25 November 2015

SF2012/015953
CR2015/005282
DC

NEW ENGLAND HIGHWAY (A15): RIX'S CREEK MINE EXTENSION PROJECT (SSD 6300),
RIX'S CREEK

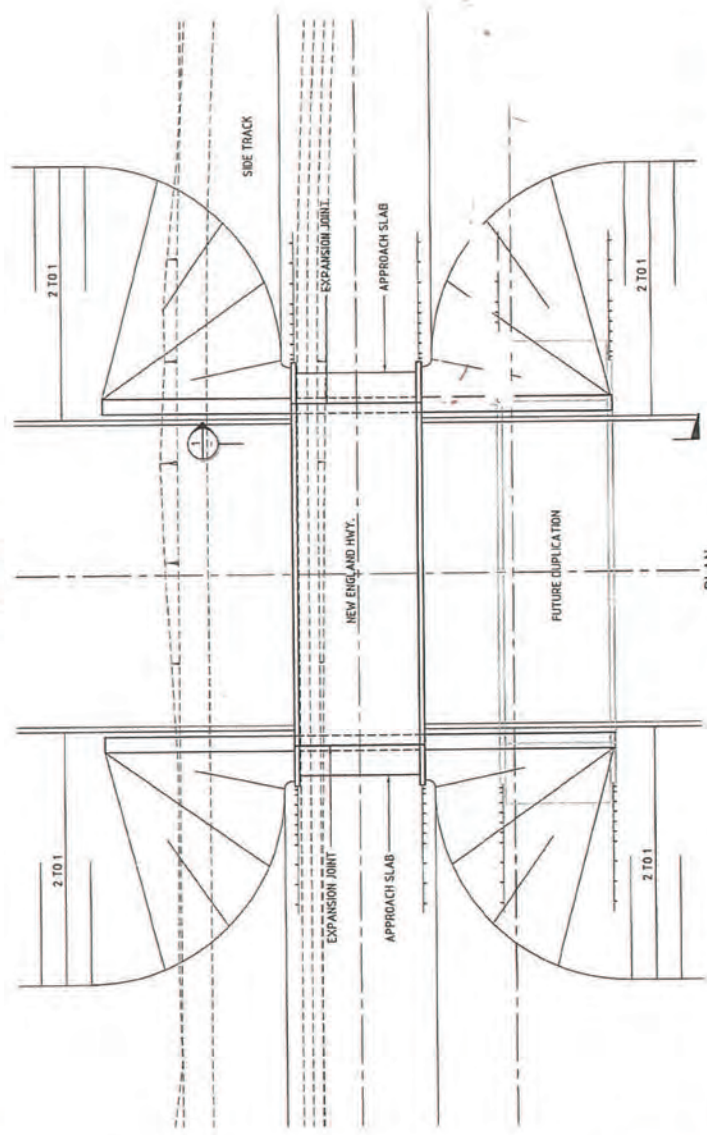
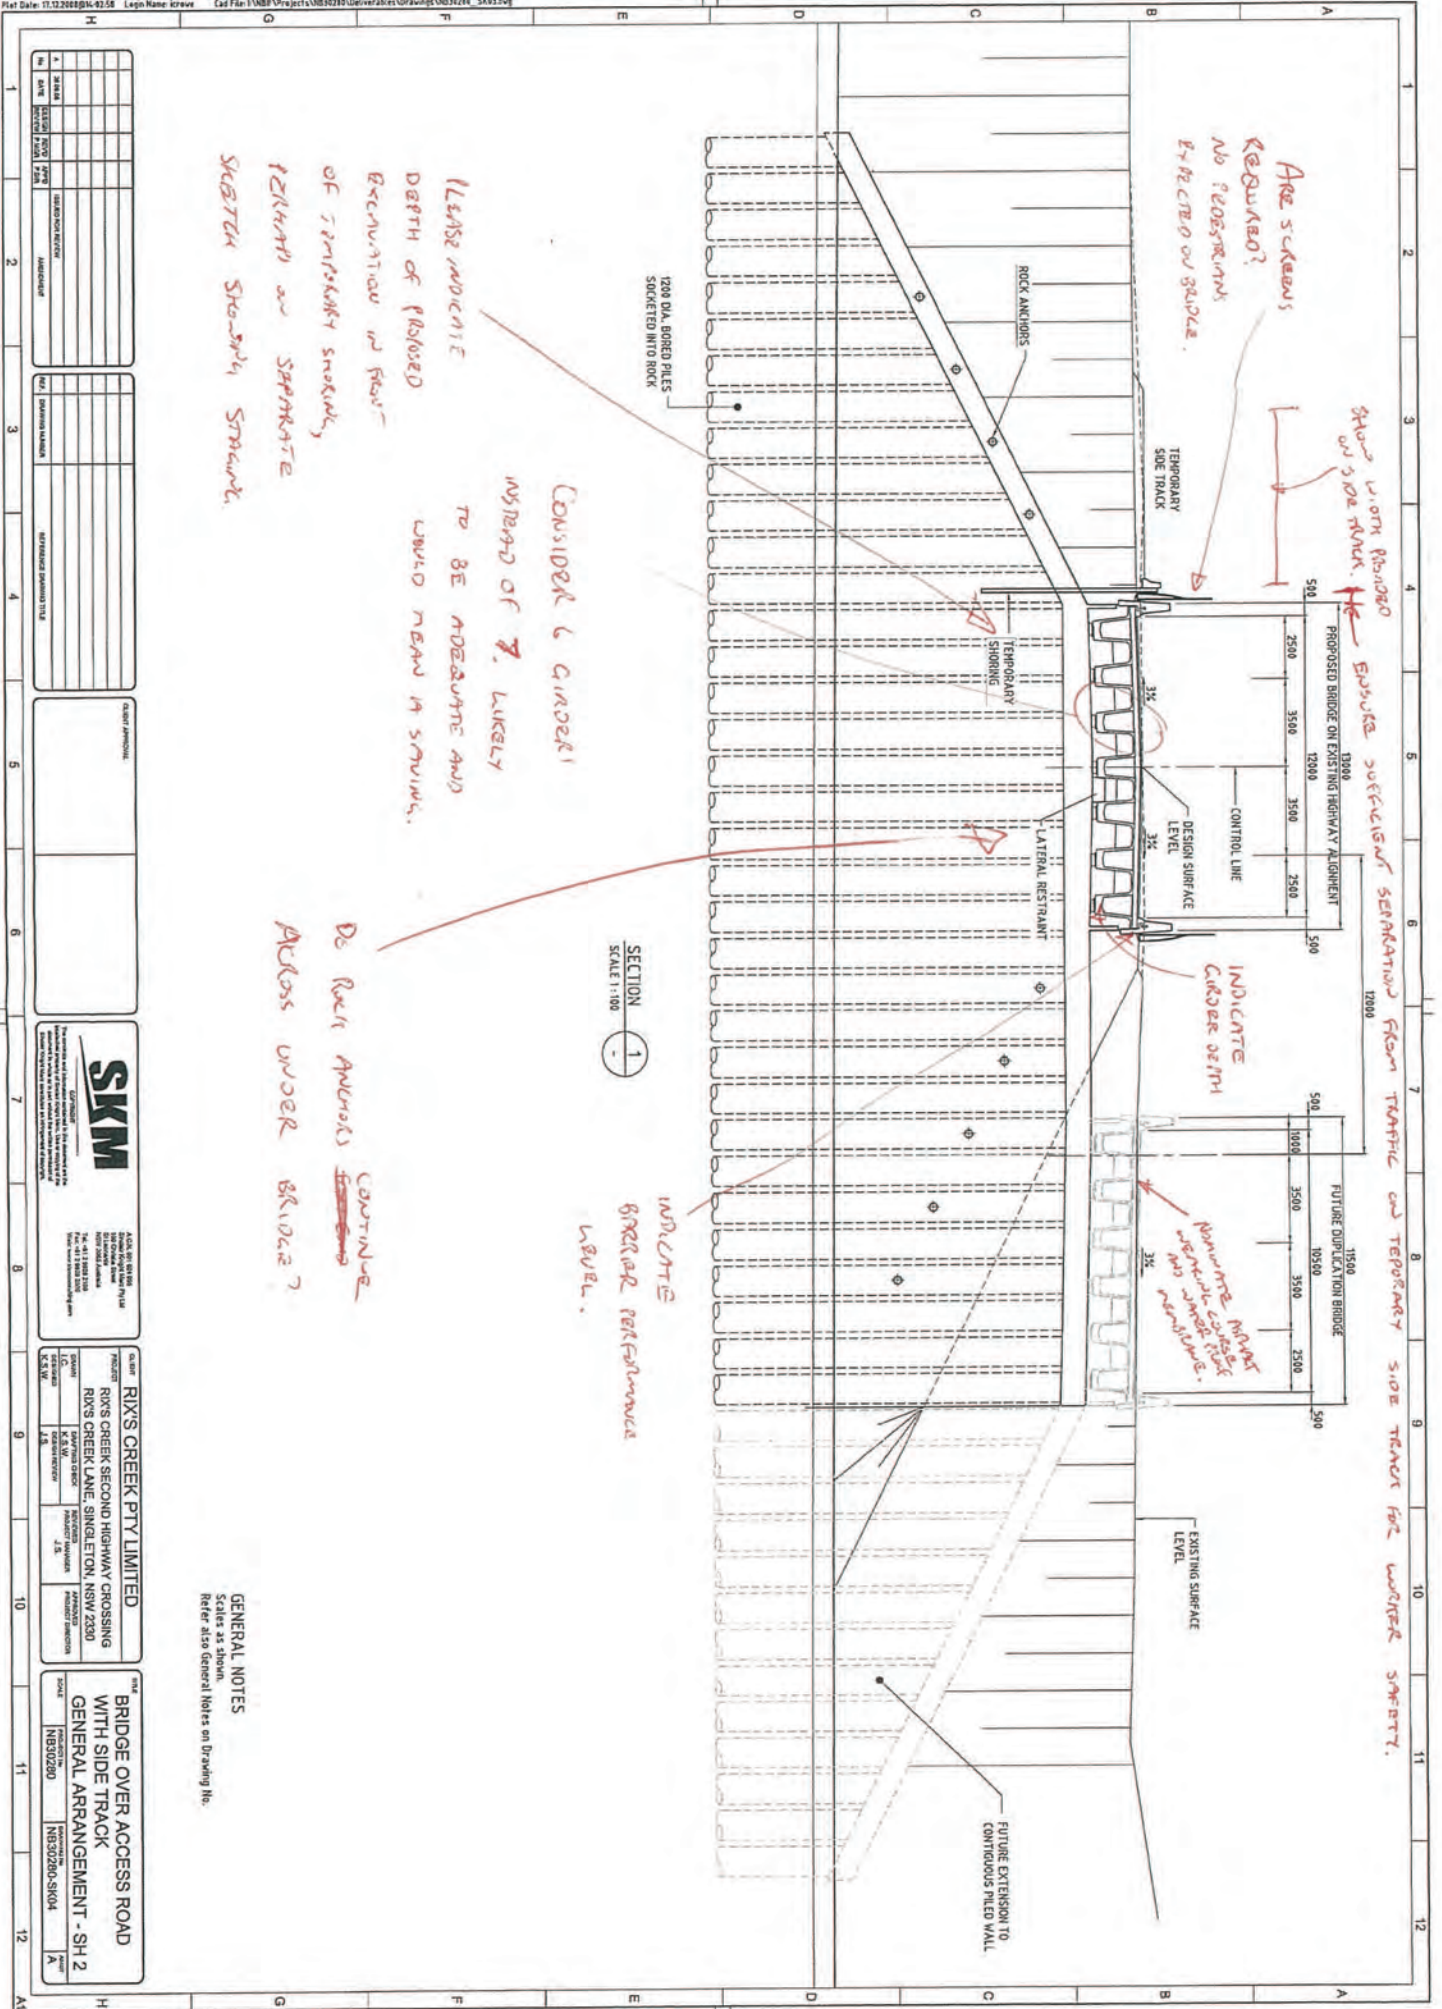
CONFIRM THAT APPROACH EMBANKMENT SETTLEMENT WILL BE LOW. 6m SLAB REFERRED.

ONE END SHOULD BE FIXED TO RESIST BREAKING FORCES.

HOW WILL ACCESS TO BEARINGS BE PROVIDED?

* BRIDGE DESIGN SHOULD CONFORM TO RMS BRIDGE TECHNICAL DIRECTIONS AND STANDARD DRAWINGS.

* SHOW LOCATION OF FIBRE OPTIC CABLE ON PLAN.

* WHAT IS INTENDED FOR THIS STRUCTURE BEYOND THE LIFE OF THE MINE? 100 YEAR LIFE?
